Consultee Comments for Planning Application 24/00014/FULL

Application Number: 24/00014/FULL

Proposal: ERECTION OF 2NO. DWELLINGS WITH ASSOCIATED EXTERNAL WORKS AND ACCESS (ALTERNATIVE PROPOSAL TO PLANNING PERMISSION 19/00235/FULL)

On Behalf Of: Building Control

CLIENT Nicholas Gillanders	RIBA Chartered Practice
PROJECT TITLE 2303 2 New Dwellings	
LOCATION Land to Rear of Green Crescent Gosport	SCALE 1:100 @ A3
DRAWING TITLE Proposed Floor Plans	DRAWN BY MP
	DATE August 2023
	DRAWING NO. 2303_P_03

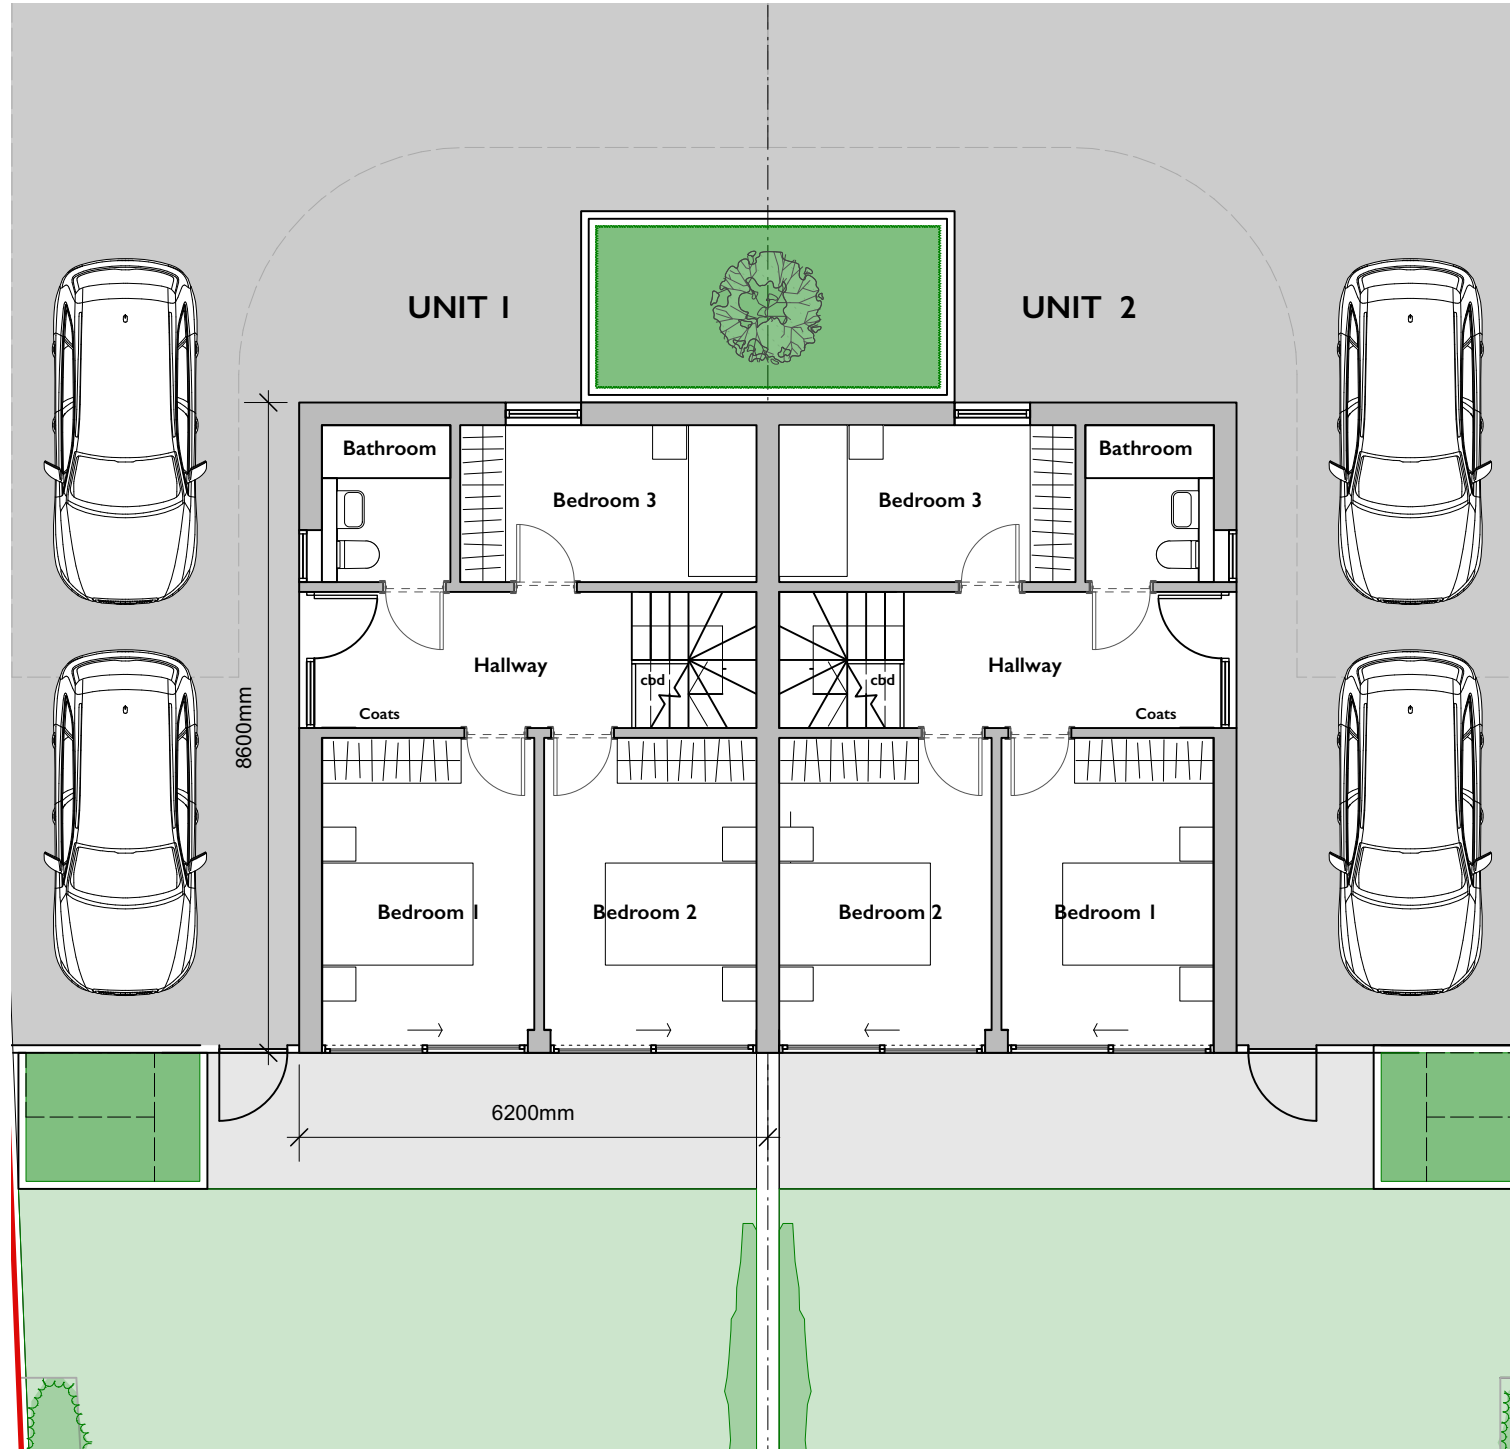
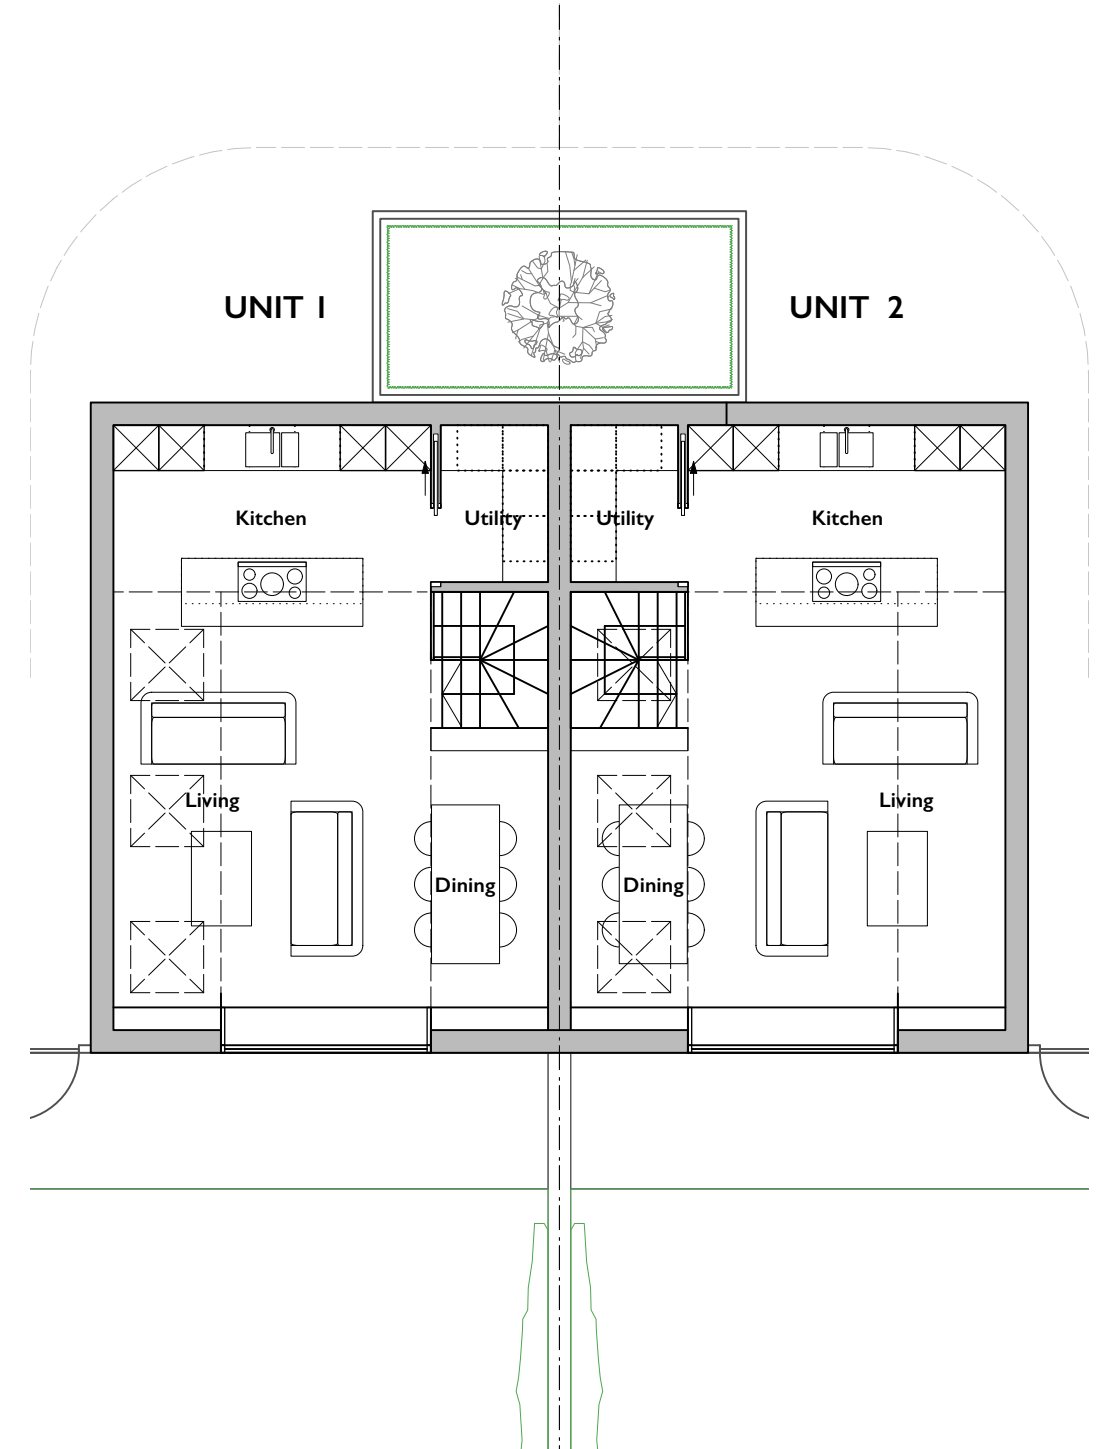
Ground floor bedroom 3 in each dwelling will require a window suitable for means of escape where the first floor living accommodation is open plan to the stairs.
